***MODIFICATION REQUEST:  
7 Railway Street, Chatswood  
MP09\_0154 MOD 1***

Director-General's  
Environmental Assessment Report  
Section 75W of the  
*Environmental Planning and Assessment Act 1979*

April 2012

8.8m MEDIUM RIGID VEHICLE
 SWEEP PATHS

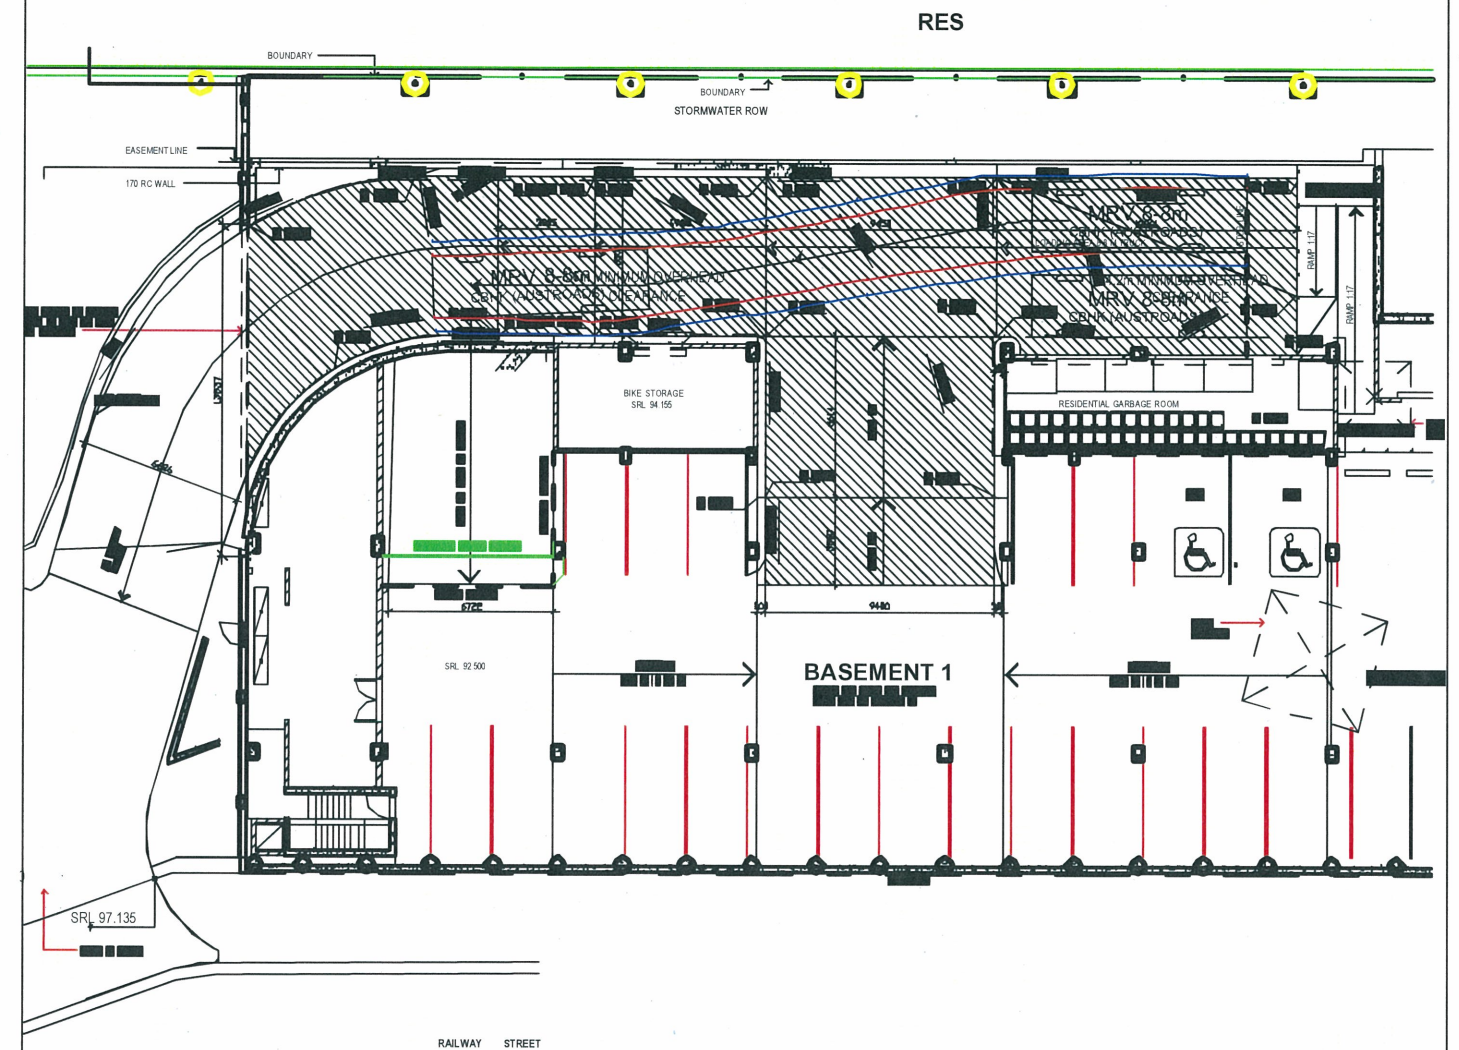
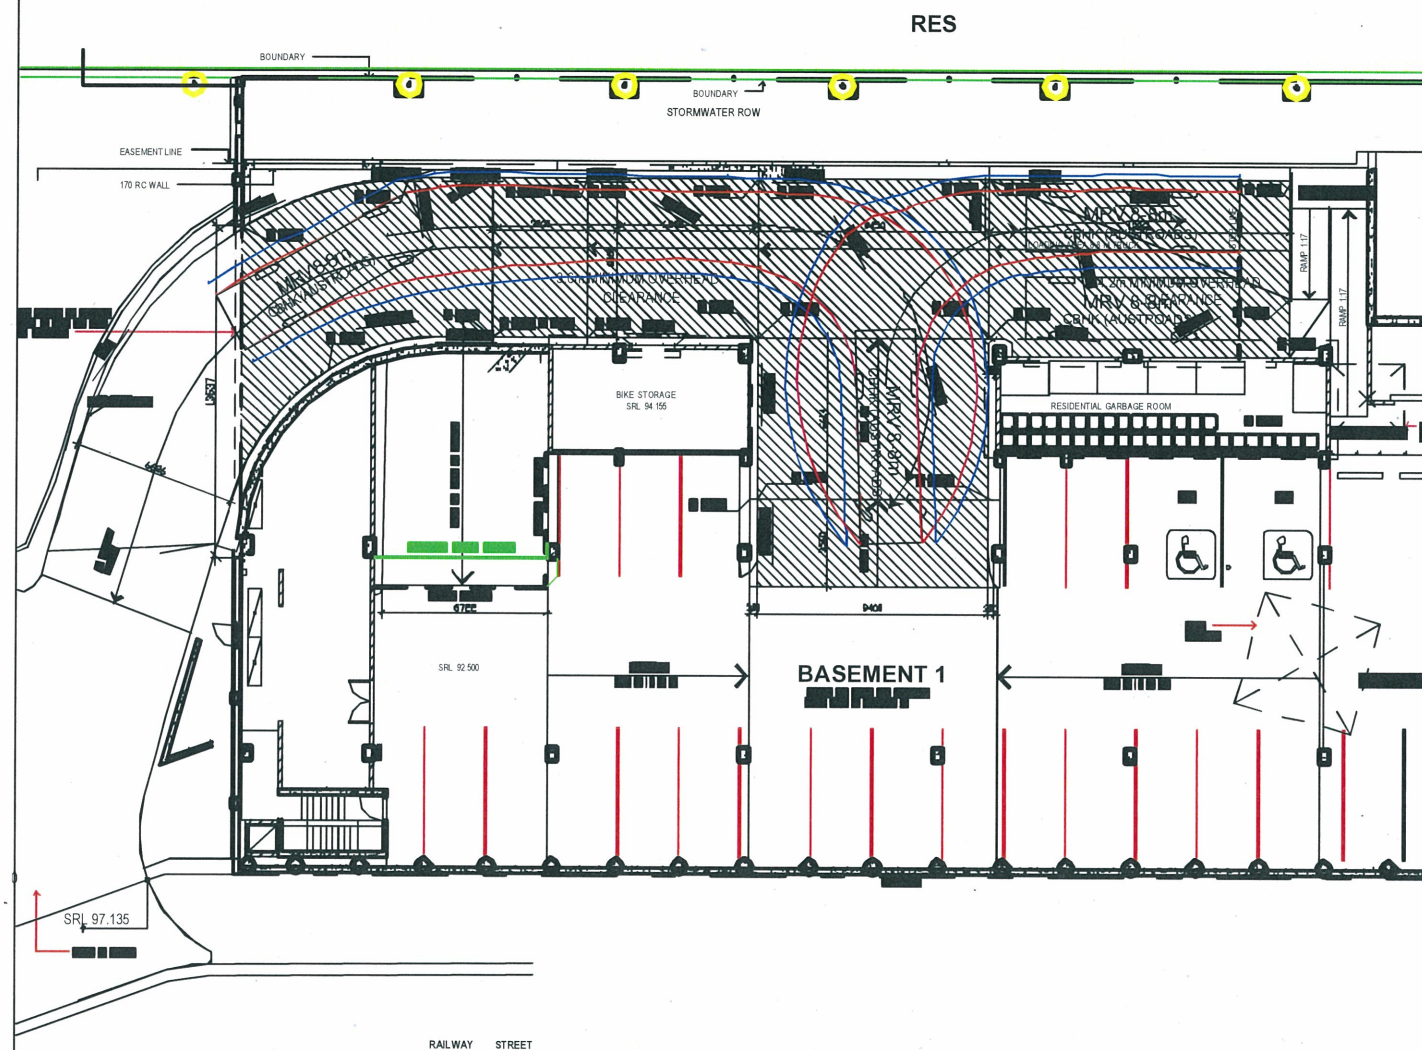
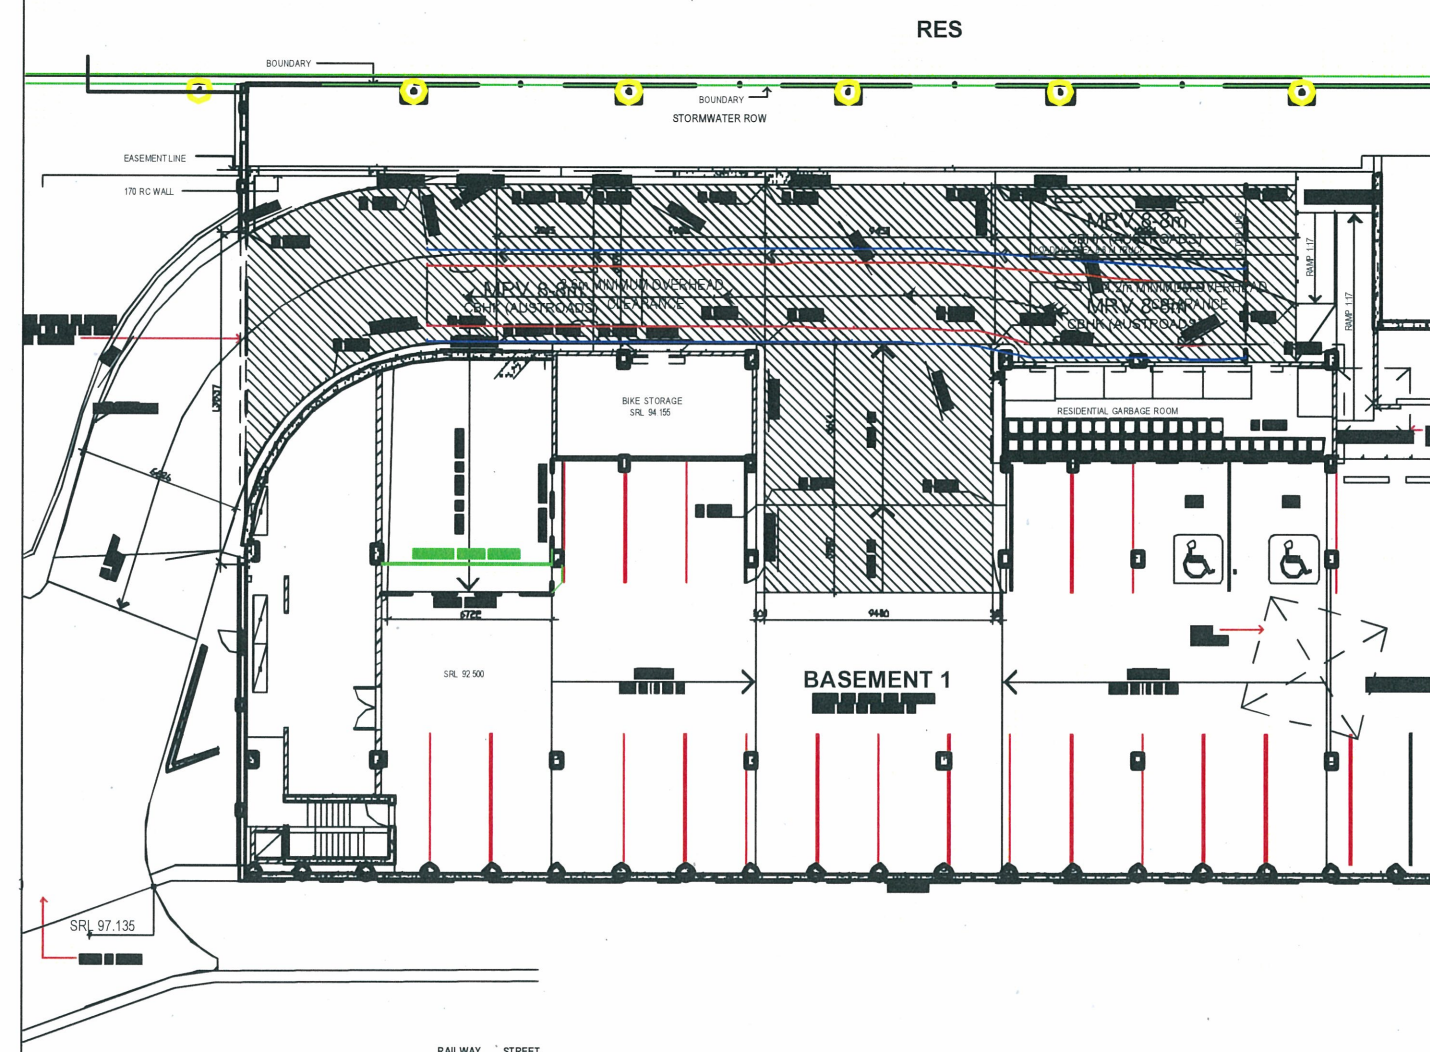
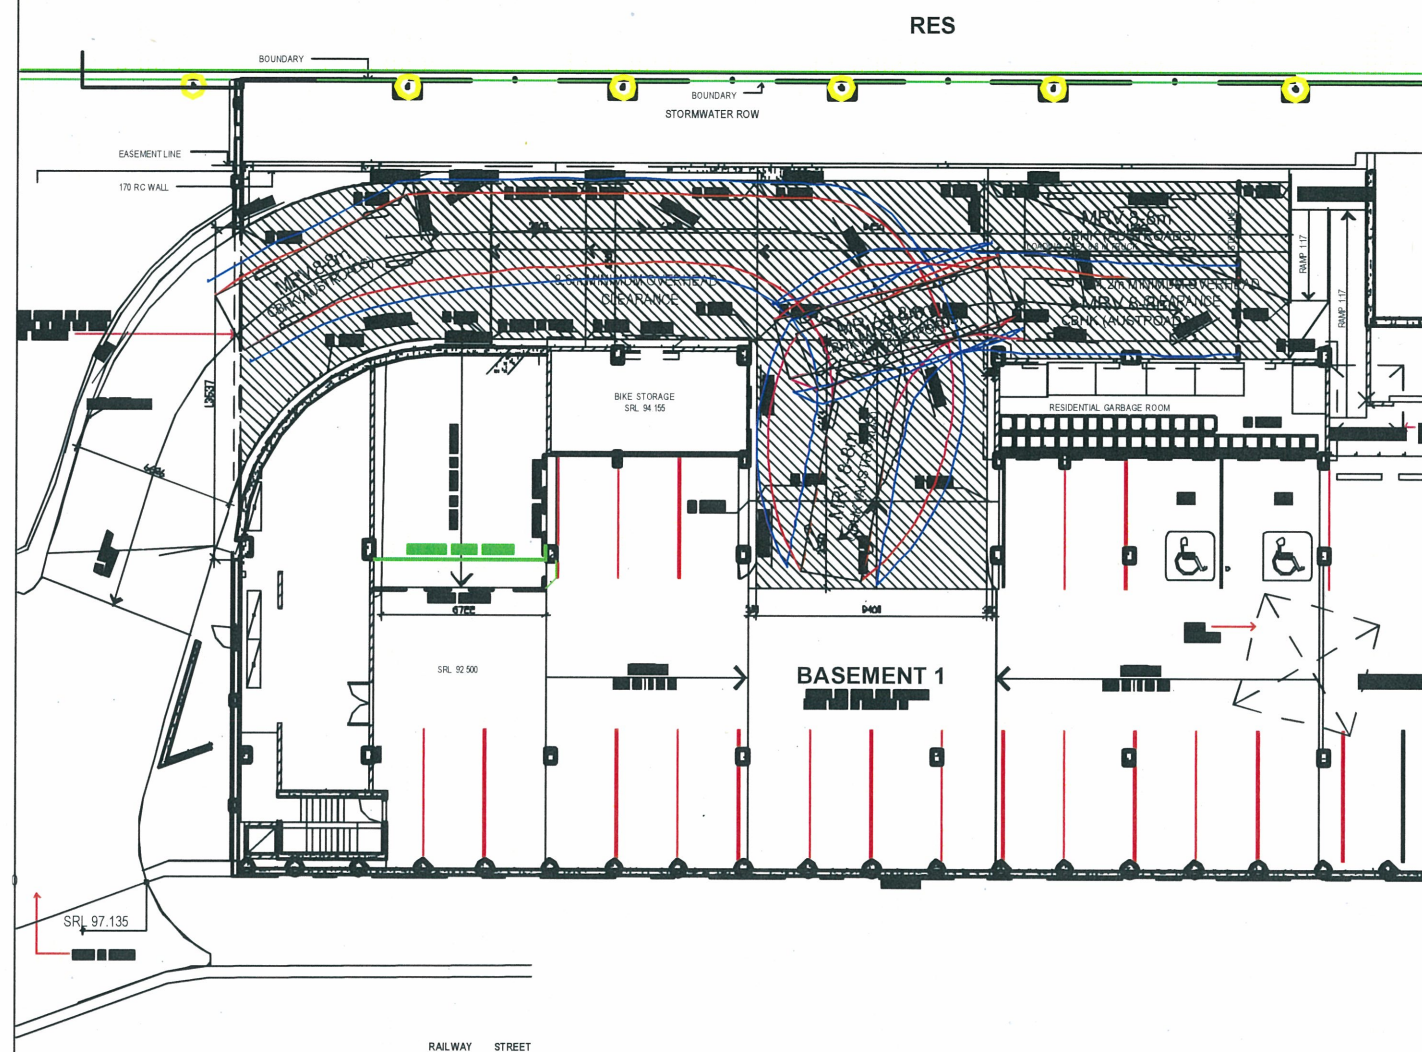
The proponent advises that it is not possible to provide manoeuvring space that is separate to and does not conflict with the access to the car park. The proponent considers that given the size of the site and required headroom it is not possible to provide a separate manoeuvring area dedicated to truck movements. Accordingly, it is proposed that trucks reverse into the loading lock by manoeuvring on the car park ramp and then exit the site in a forward direction.

It is proposed to manage potential conflicts between reversing trucks and cars through a traffic signal system. The traffic signal system will operate at all times and involve detector loops and height sensors which will detect when a truck is entering and exiting the loading area. The proposed traffic signal system is shown in **Figure 4**.

Council objects to any amendment to the existing condition and considers that the provision of an additional half basement level should be provided so that the delivery/waste collection does not conflict with cars using the car park.

RMS originally raised objection to the proposed amendments and considered that the proponent did not adequately demonstrate how the conflict between trucks and cars will be addressed and the measures put in place to ensure that access and safety to the car parking access is not compromised.

The Department is satisfied that the proposed traffic signal system, as agreed to by RMS, will ensure that both trucks and cars can safely access the site. The traffic signals will ensure that the potential conflict between reversing trucks and cars is removed.

On this basis, the Department supports the proposed traffic signal system to remove the potential conflict between trucks and cars. It is therefore recommended that Condition B2(g) be amended to delete the requirement for separate manoeuvring space and require the implementation of the proposed traffic signal system instead.

7 Railway Street Chatswood | Section 75W submission

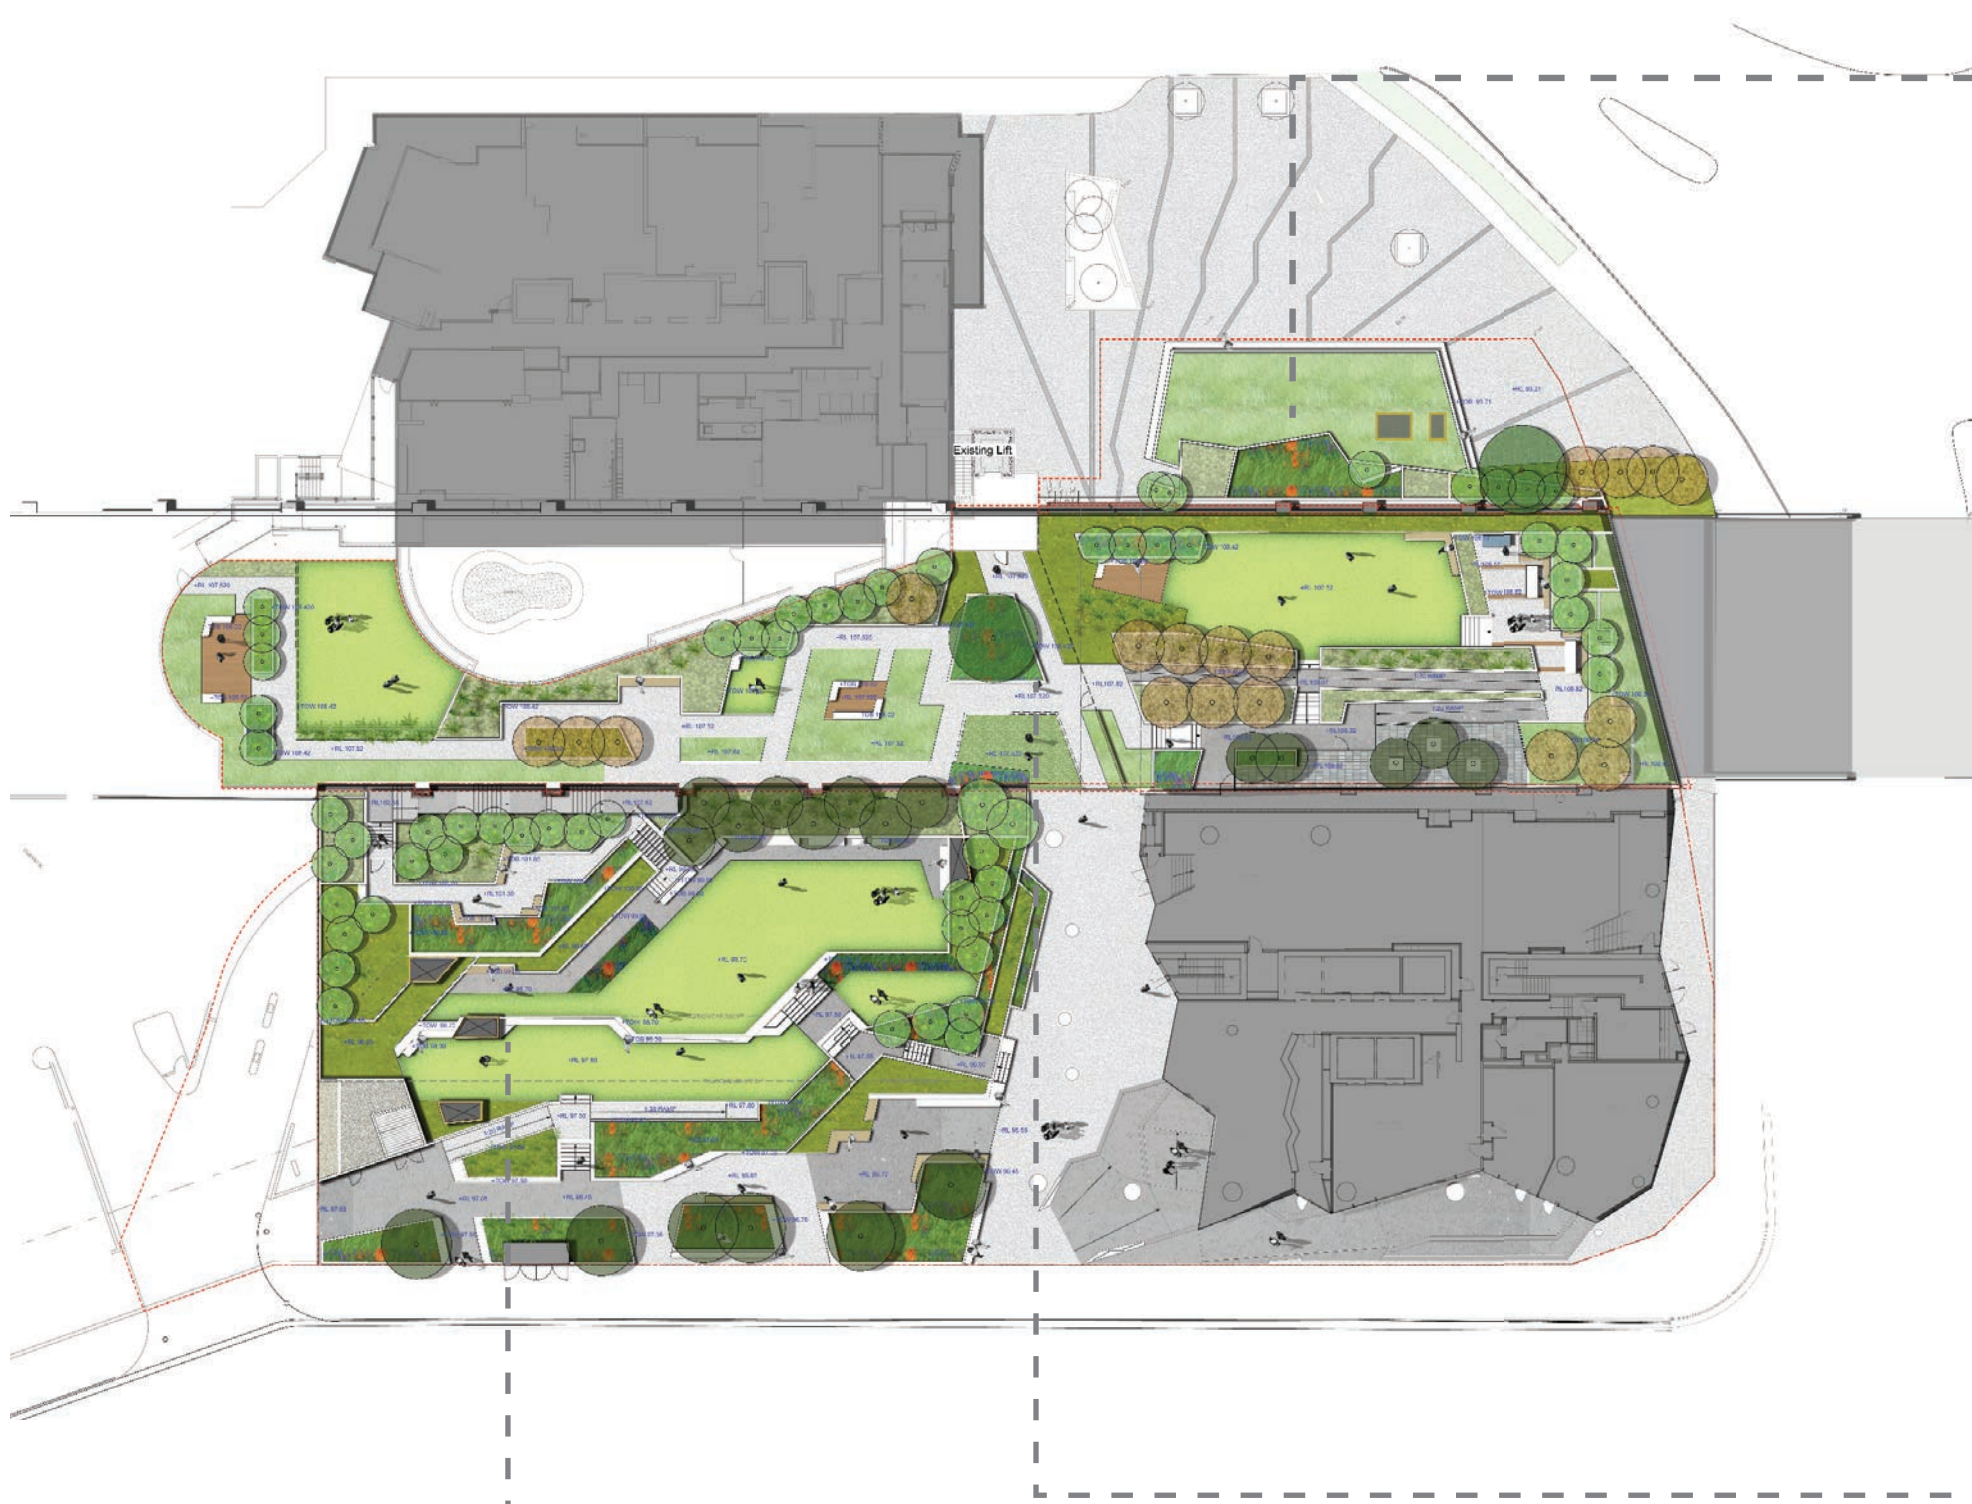
The proponent proposes to delete the street trees and provide replacement trees within the boundary in planters along the western portion of the Railway Street frontage. Refer to **Figure 6**.

Council considers that the street trees are an essential element within the Chatswood CBD to enhance the public footpath, provide shade and rain cover, mitigate wind impacts and soften the scale of buildings for pedestrians. Council considers that the services located within the footpath can be relocated.

The Department supports the proposed alternate planting within the property boundary given the difficulty and cost (estimated at \$1 million lost revenue per day) associated with the relocation of the major Telstra fibre optic cables. The tree planting within planters is also consistent with the landscape character established for Railway Street (refer to **Figure 7** above). The wind impacts associated with the deletion of street trees are discussed in **Section 5.4**.

On this basis, it is recommended that Condition E17 be deleted, subject to the revised landscape plan featuring additional trees within the property boundary being approved as part of Condition A2.
